Reference: **A38 Junctions Interested Party Statement from Derby Cycling Group**

We have reviewed the A38 Derby Junctions scheme in terms of its impact on existing active travel routes (ie those used for cycling and walking) and on its potential to create new and improved active travel routes and infrastructure. We see significant opportunities to gain huge benefits for **local** travel as well as for long distance through-journeys, especially by enabling more everyday journeys to be made by bicycle. However, **not enough regard is being taken of outcomes for cycle transport within the project's basic terms of reference.**

**KINGSWAY JUNCTION  
PROPOSED CONSTRUCTION  
SEQUENCE  
PHASE 1**

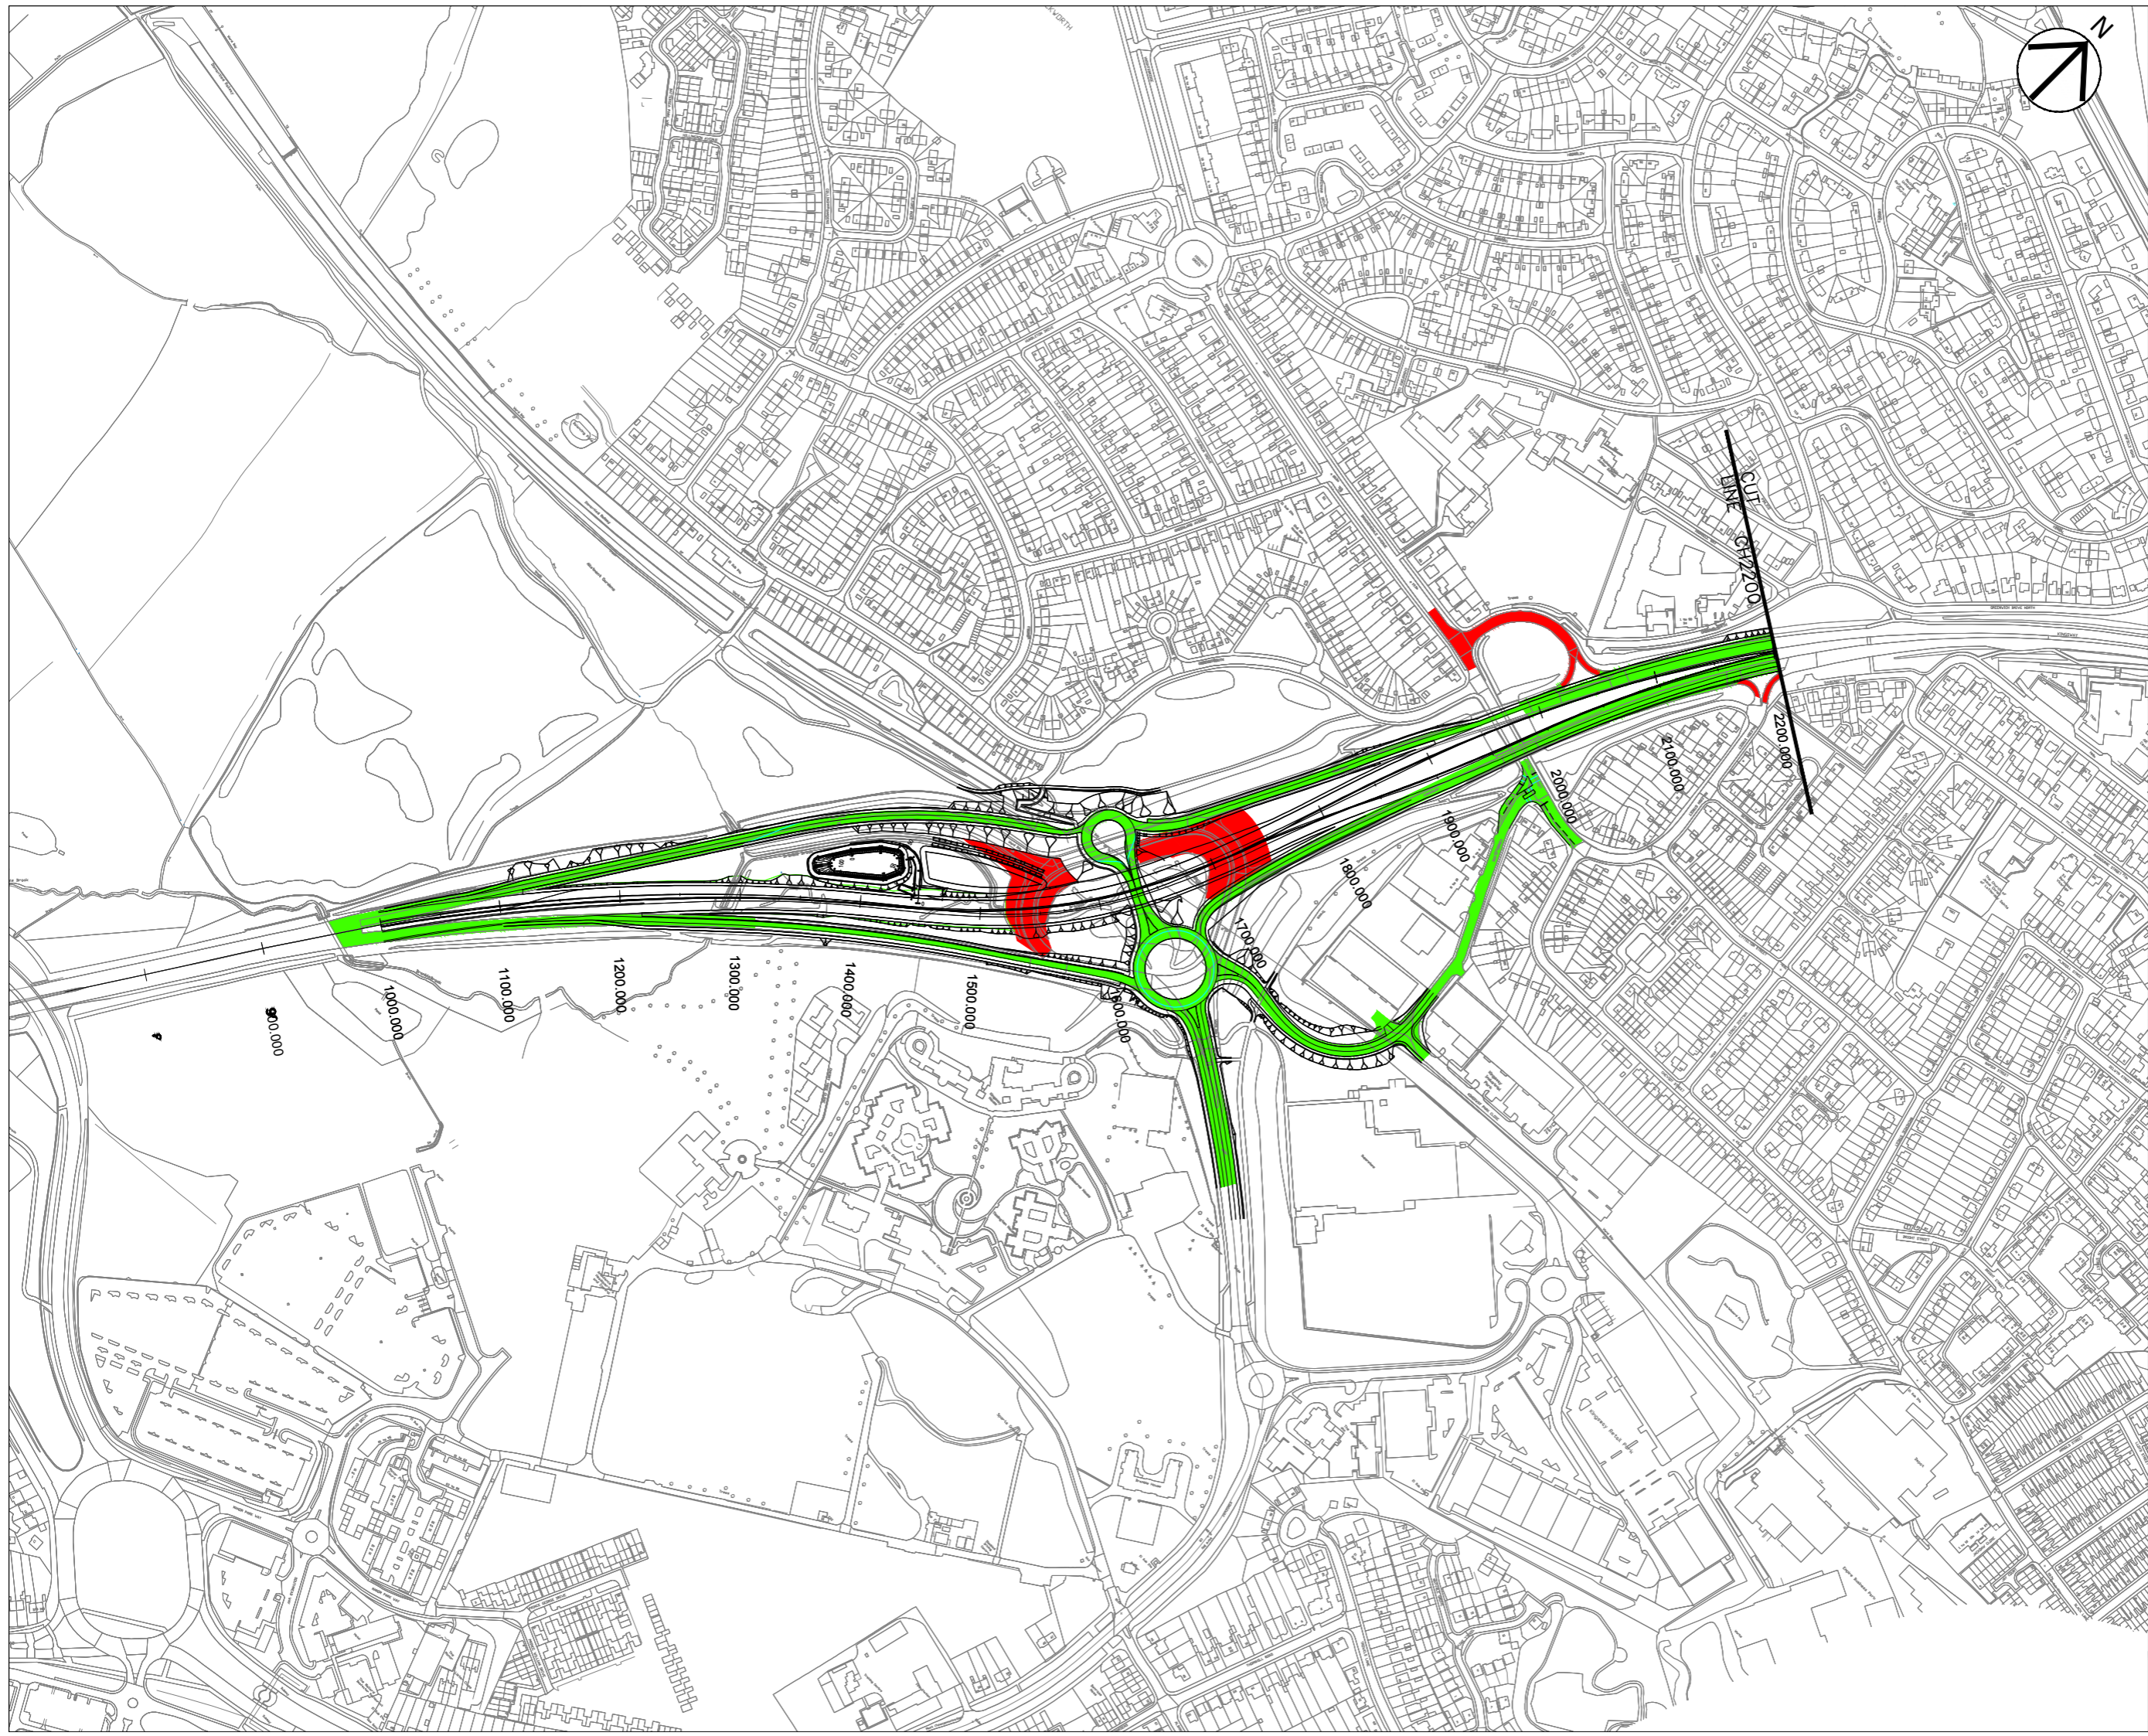
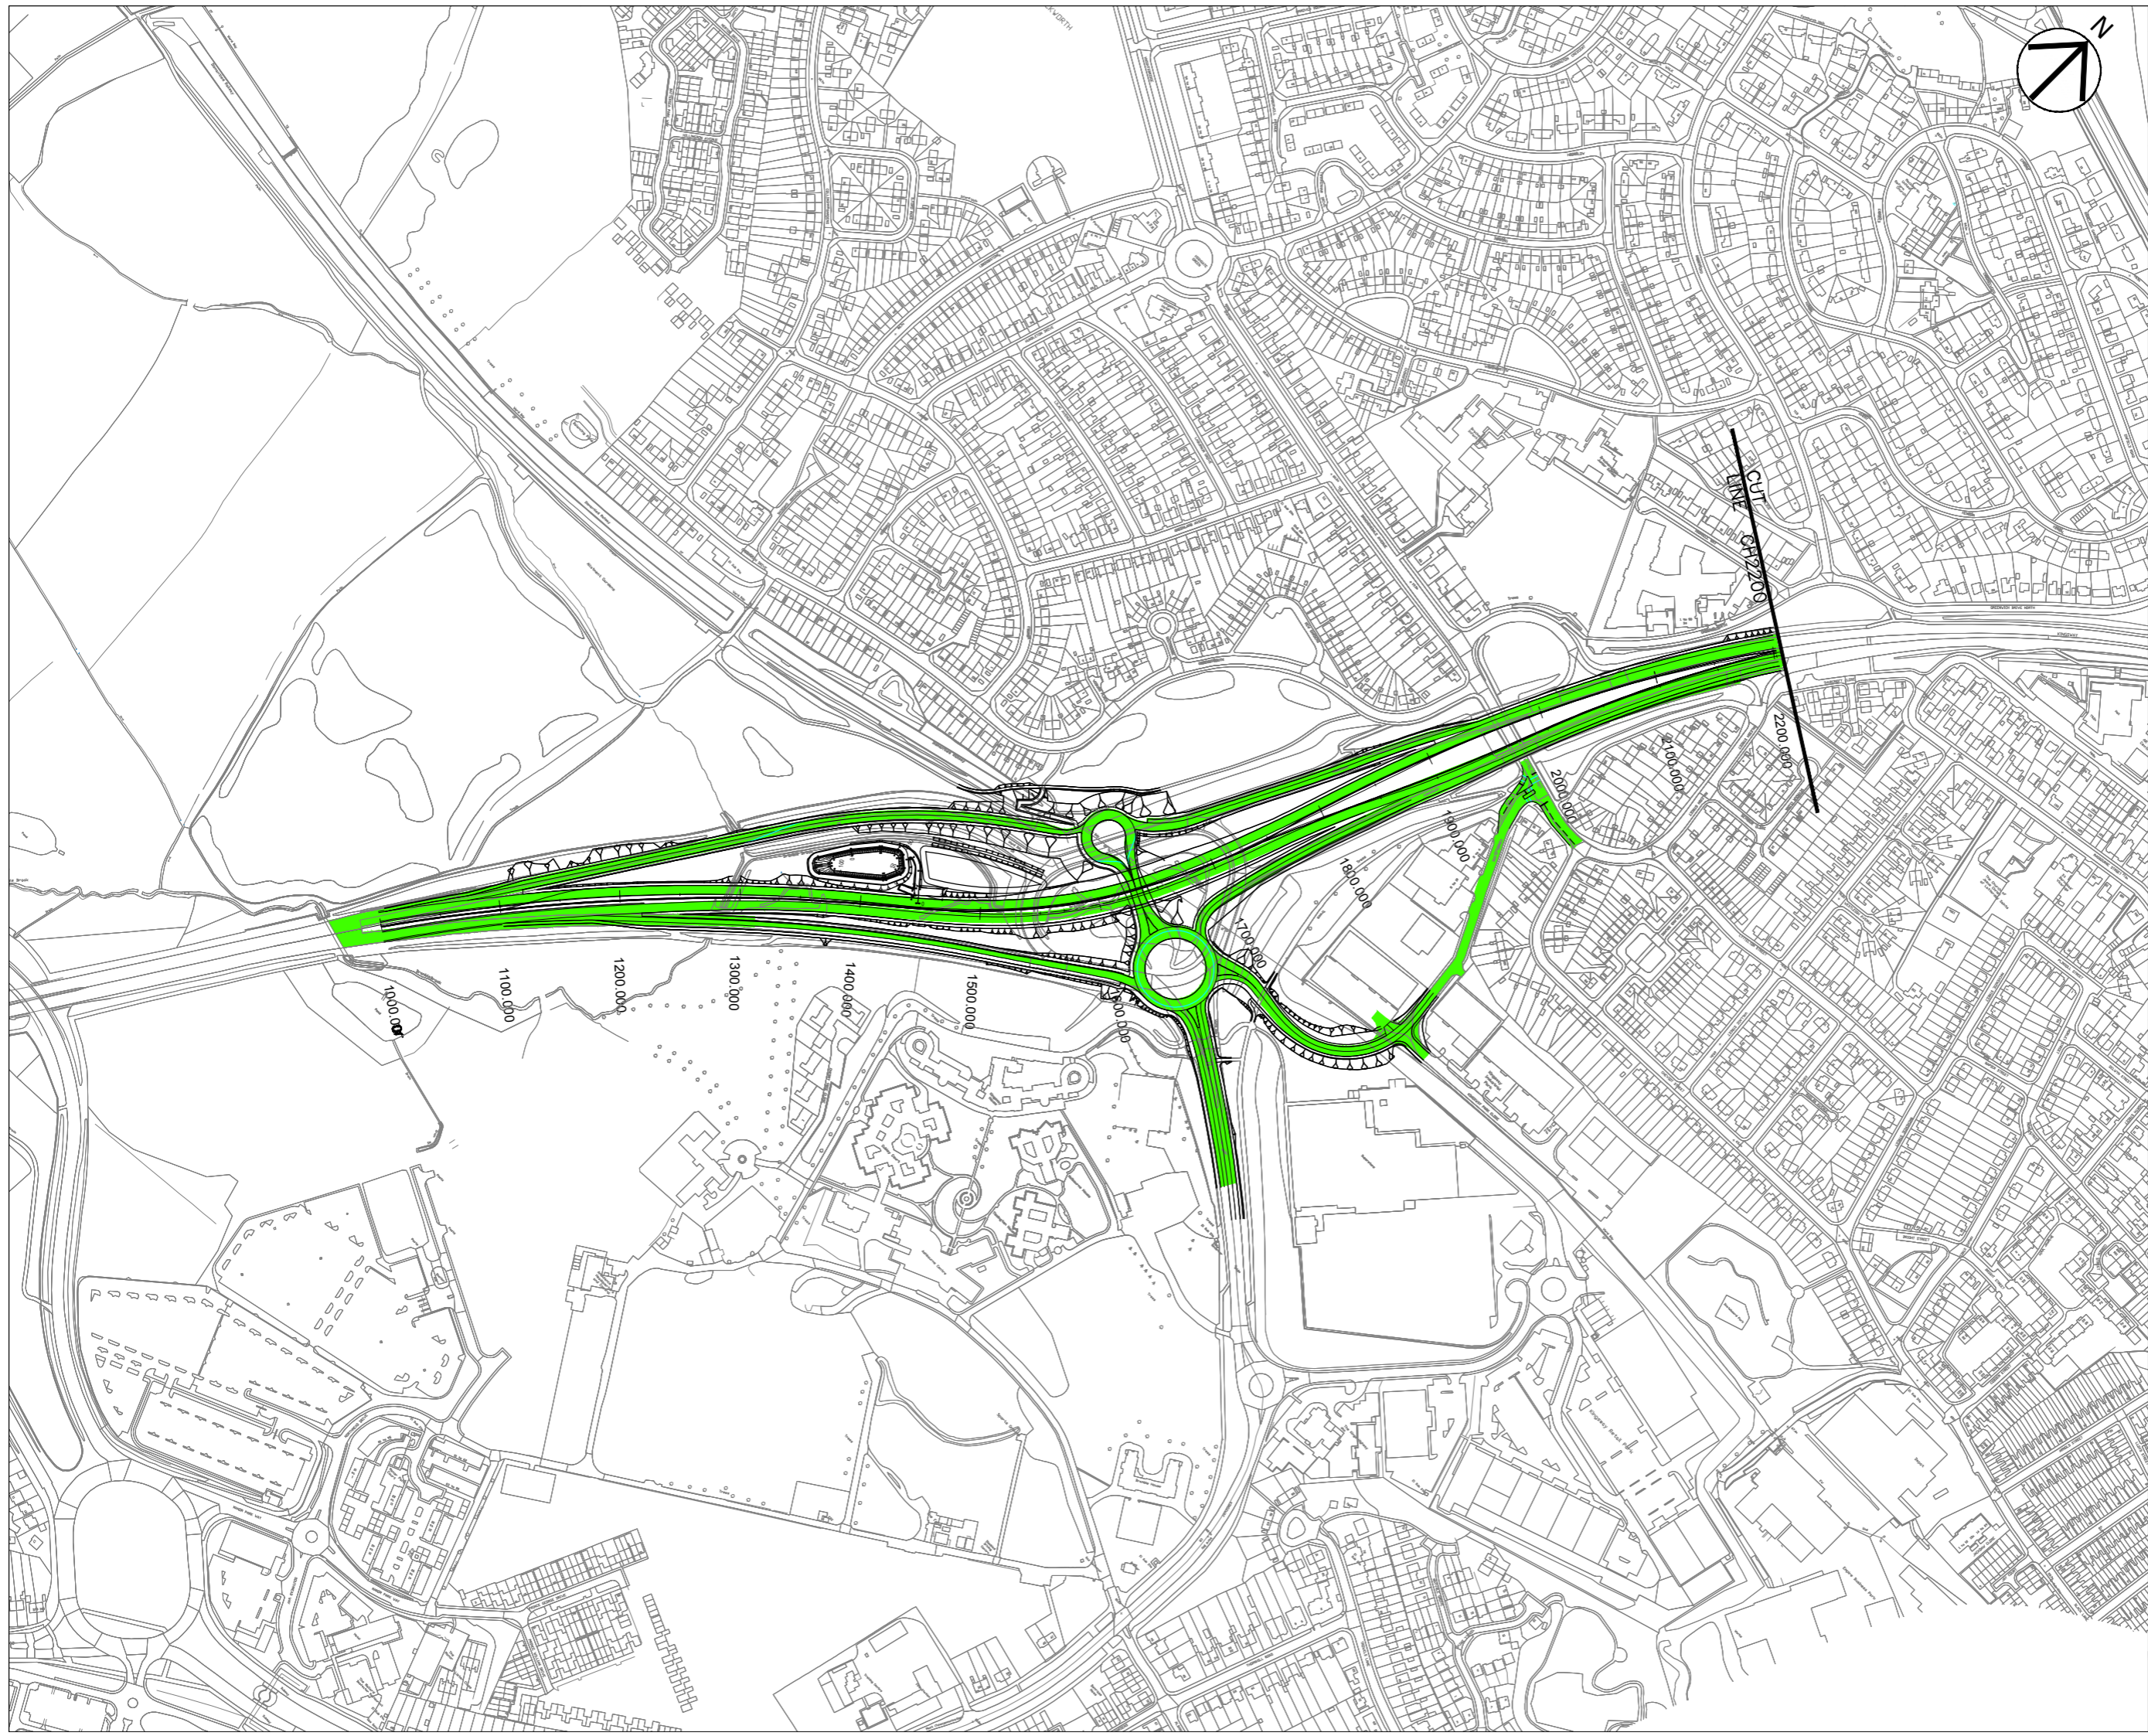
- Uncontrolled crossings over two lanes of traffic on slip roads at the Kingsway junction
- Discontinuous cycle routes and the lack of a controlled crossing on the A52 across the entrance to the Macdonalds/Esso garage site
- A significantly sub-standard route (ridiculously narrow) alongside the A38 between Little Eaton island and Ford Lane where it crosses the rail bridge.
- Lack of marked crossings over the Ford Lane exit from the Little Eaton junction and at the Starbucks entrance.
- A general reluctance to introduce segregation: pedestrian/cycle segregation should be the standard because these routes have the potential to become very well used, and indeed the A61 cycle path already is well used.
